Mr Gosling,

Please find the Highway comments attached. They are not objecting but do recommend a few conditions. One thing they would like changed is in terms of access, outlined below:

'Access

Block Plan

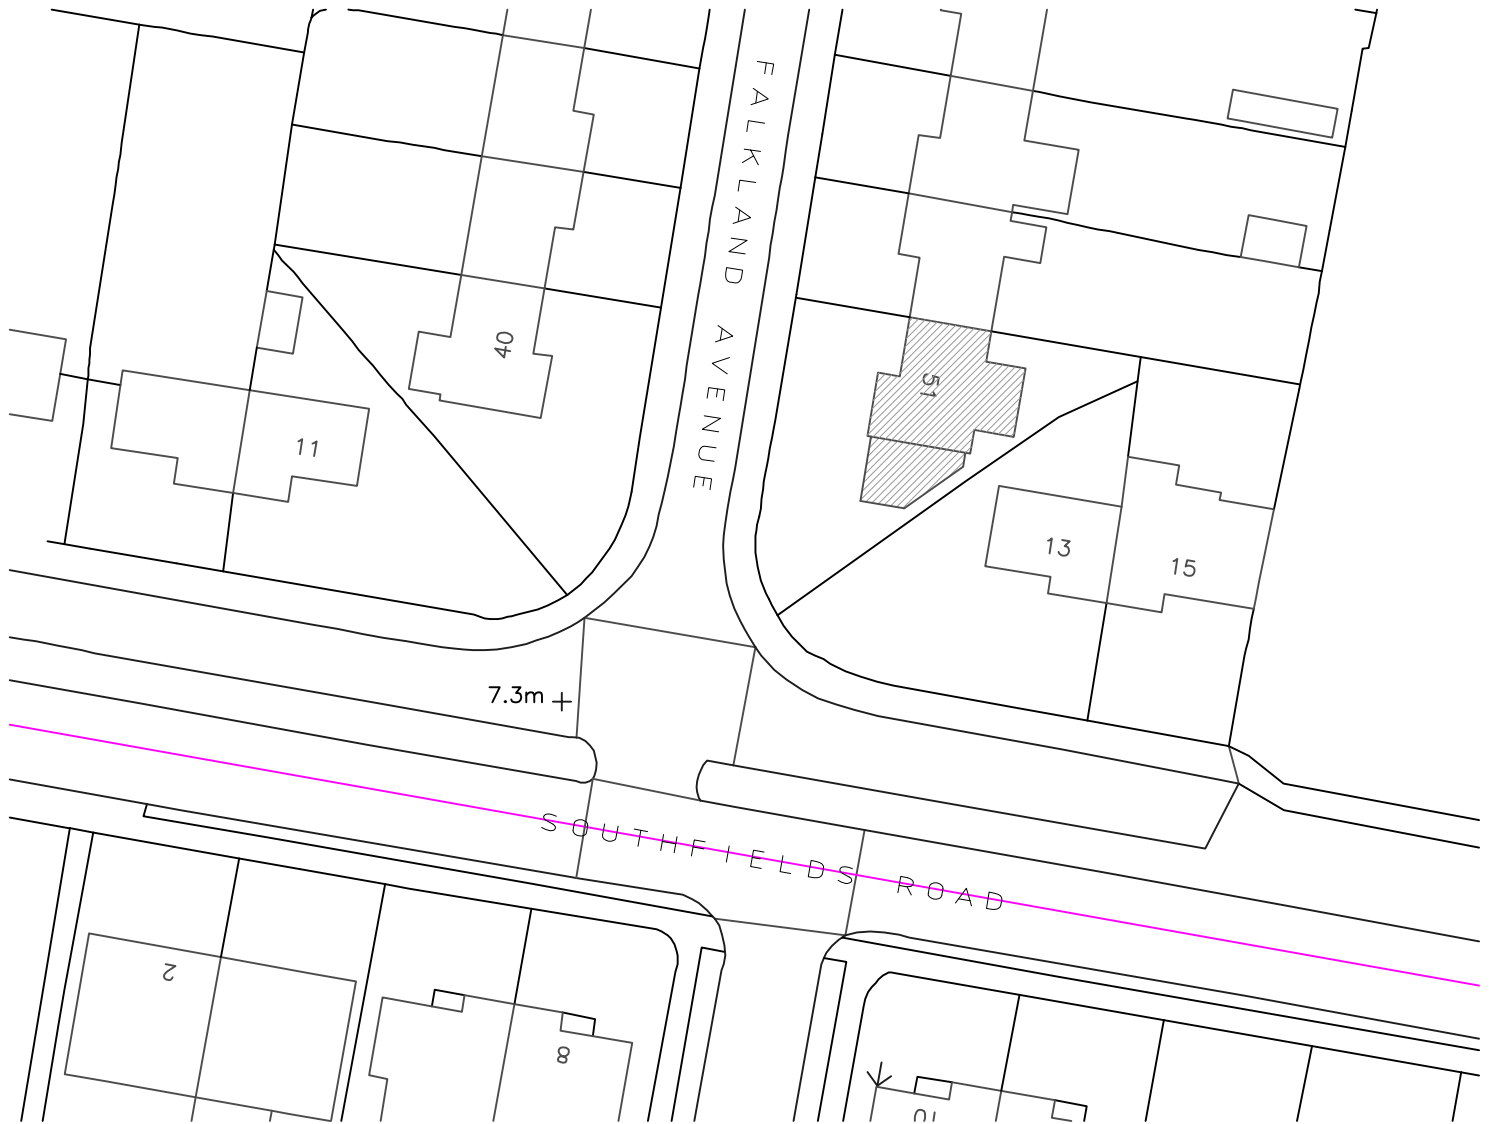
This proposal includes construction of two additional vehicle crossovers (VCO) to accommodate the proposed parking provision. I have consulted the Area Manager to provide their comments in relation to the proposed VCO. They have advised that rather than two separate VCOs, the full height kerb between the two proposed VCOs should be dropped, providing a wider, shared VCO. Any access works onto the public highway must be constructed under a licence obtained from WSCC Highways to a specification agreed with them'.

Could you send in an amended plan incorporating this wider single vehicle crossover please?
